Winchester
City Council

Case No: 19/00522/NSIP

29 April 2019

Subject: National Strategic Infrastructure Project to be considered under Planning Act 2008 (as amended) by Aquind plc consisting of cross channel electricity connection, with landfall at Eastney, underground cable routed along highway to converter station adjacent Lovedean sub station Broadway Lane Waterlooville.

Aquid Countryside Option

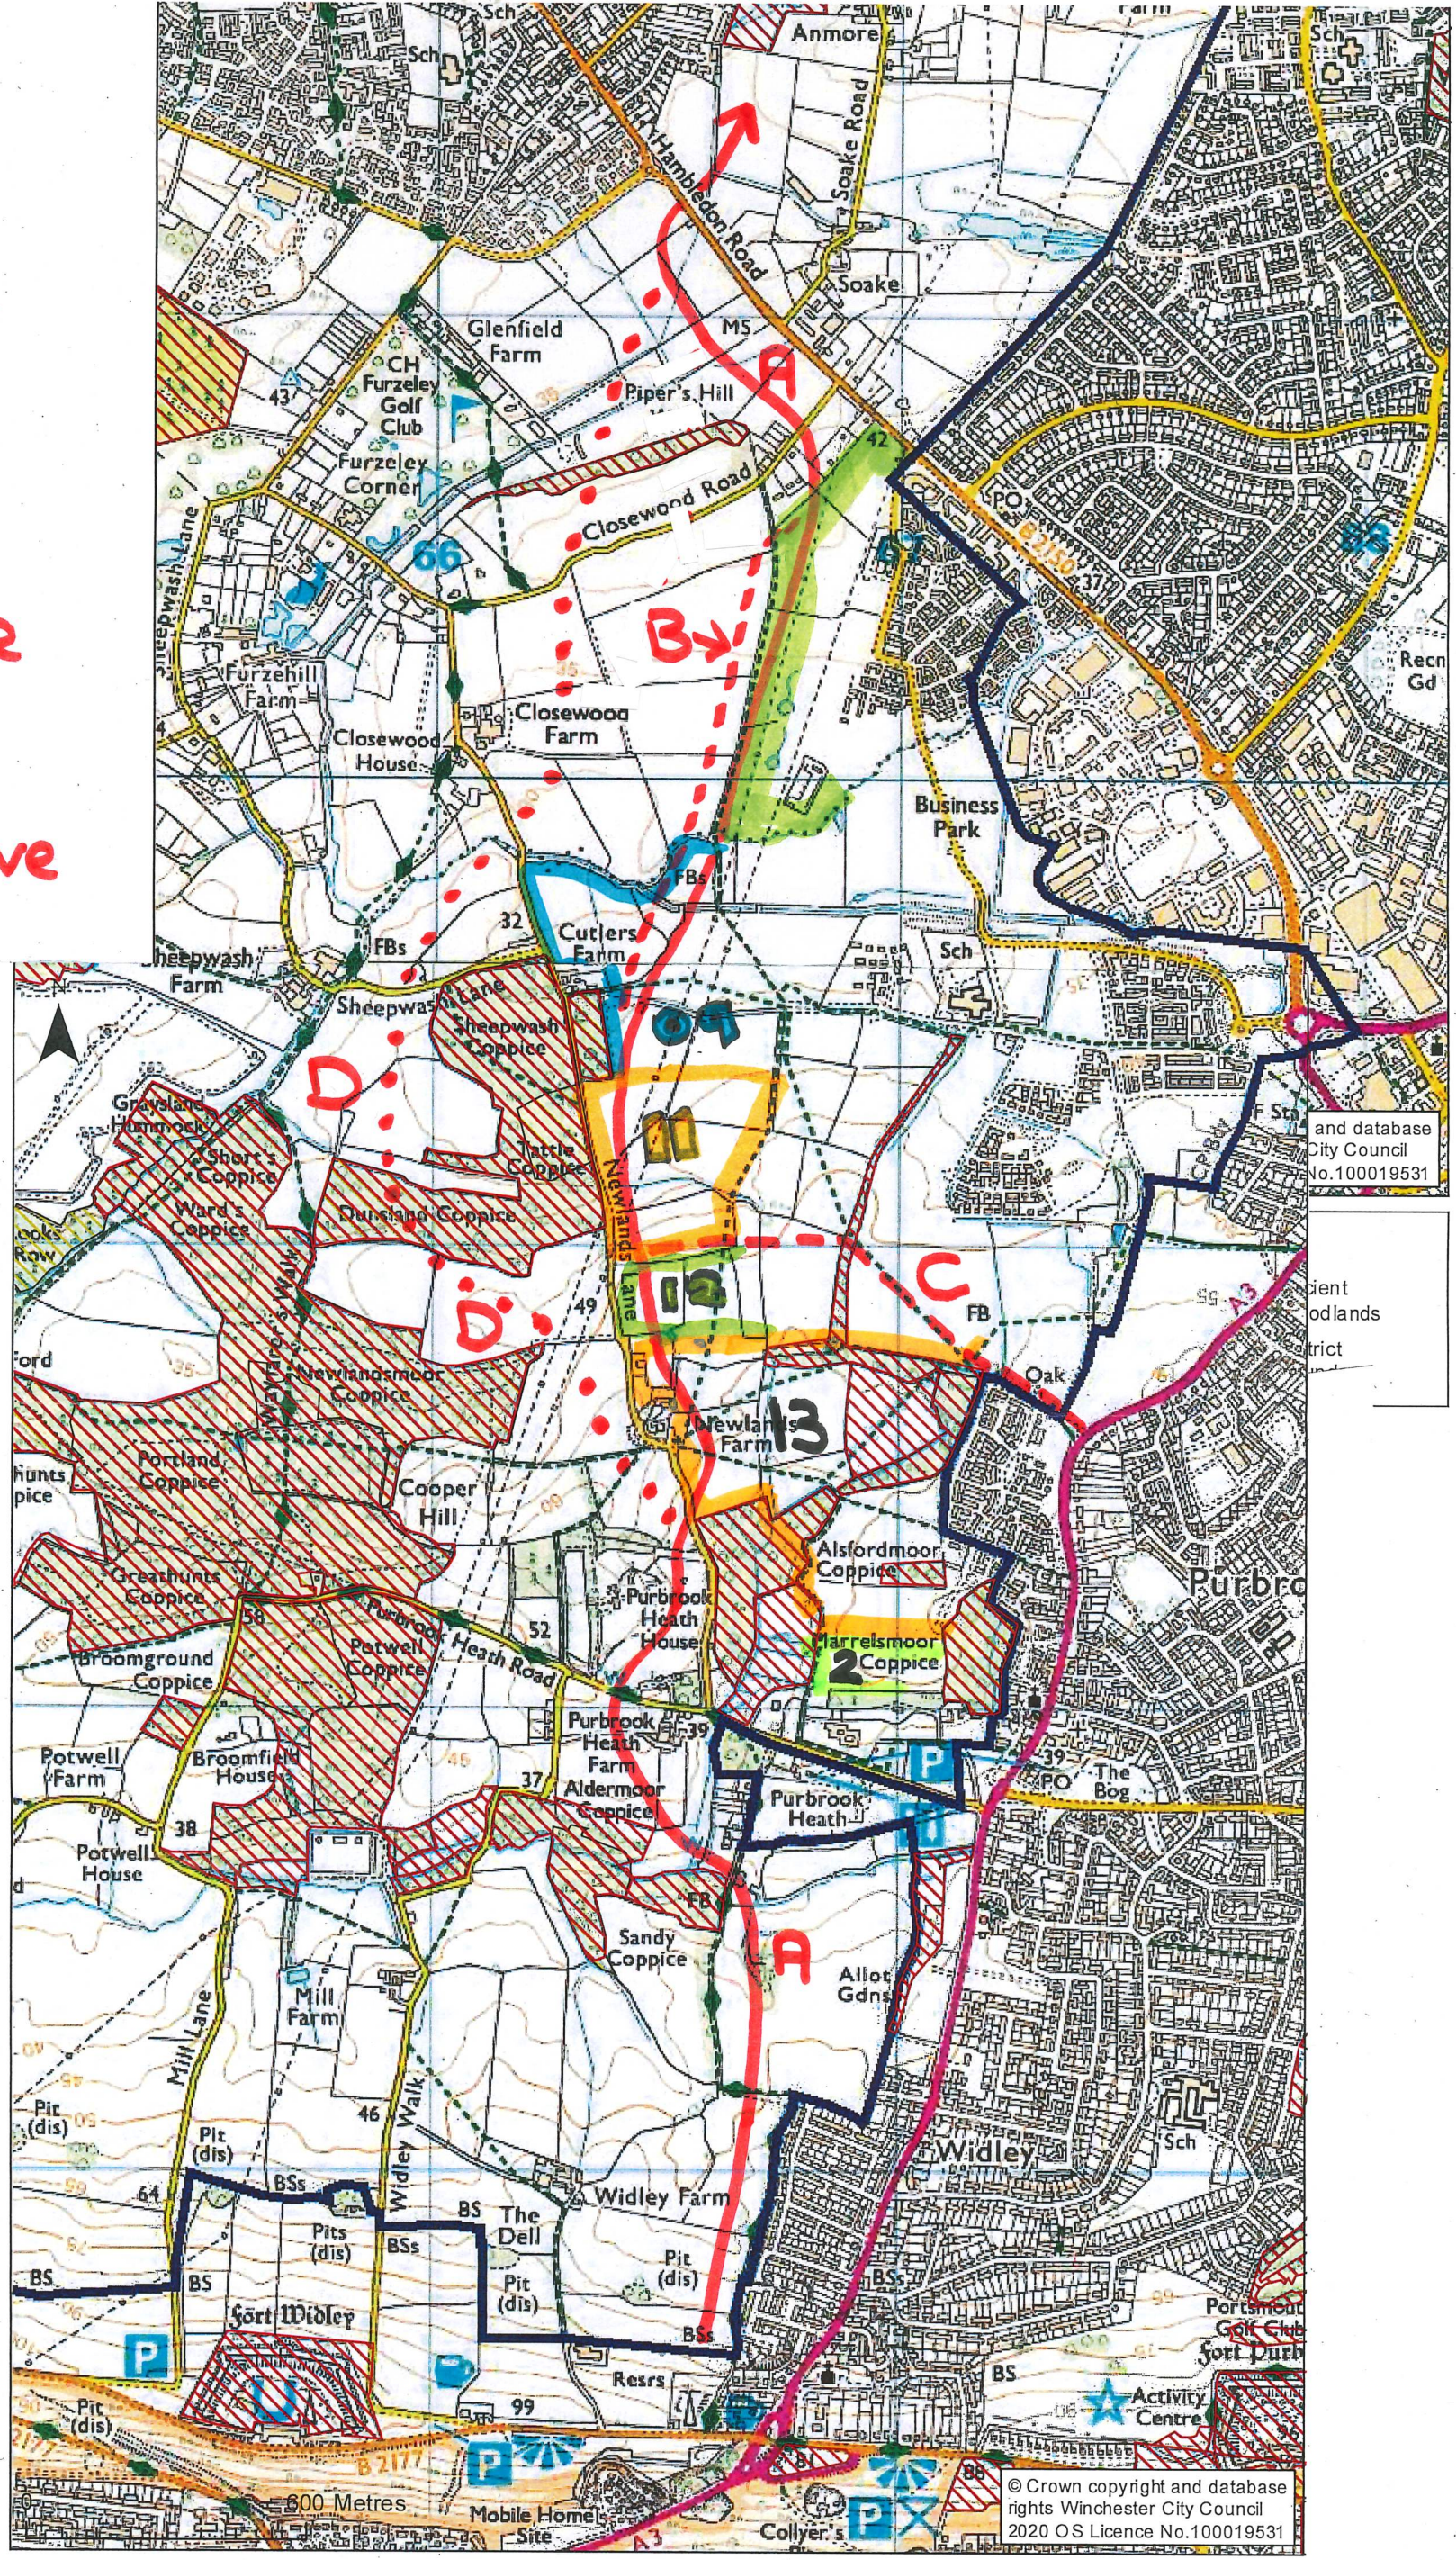
The need for such a review is necessary as a potential and realistic alternative may exist. This is the “countryside route” running northward through land to the west of the built up area of Widley and Purbrooke. A plan is attached to this comment showing an indicative route. Whilst the countryside route may have some constraints, the road route is not without its complications. The benefits of the road route appear to favour the applicant, with all the negatives aspects falling on the public and public bodies. These constraints are not simply confined to the delays that road users will suffer, but will also extend into the future as the presence of the cable hinders road infrastructure improvements over the next 40 years (the life of the cable). Measures by Aquind to address these concerns such as laying the cable at depth are likely to increase costs and installation time with the consequential additional delays to road users. The difference in the installation speed with more rapid progress across open ground than on the highway is a factor already acknowledged by Aquind.

Without an open assessment of the merits of the alternative cable routes, it is difficult to see how the applicant can show that a meaningful evaluation of the options (as required by the regulations) has taken place. This applies even if the outcome were to support the road option. Accordingly, the project should pause so that the options can be assessed in close discussion with the relevant local planning authorities (LPAs). Within that process, the constraints and benefits of the alternative routes can be fully reviewed.
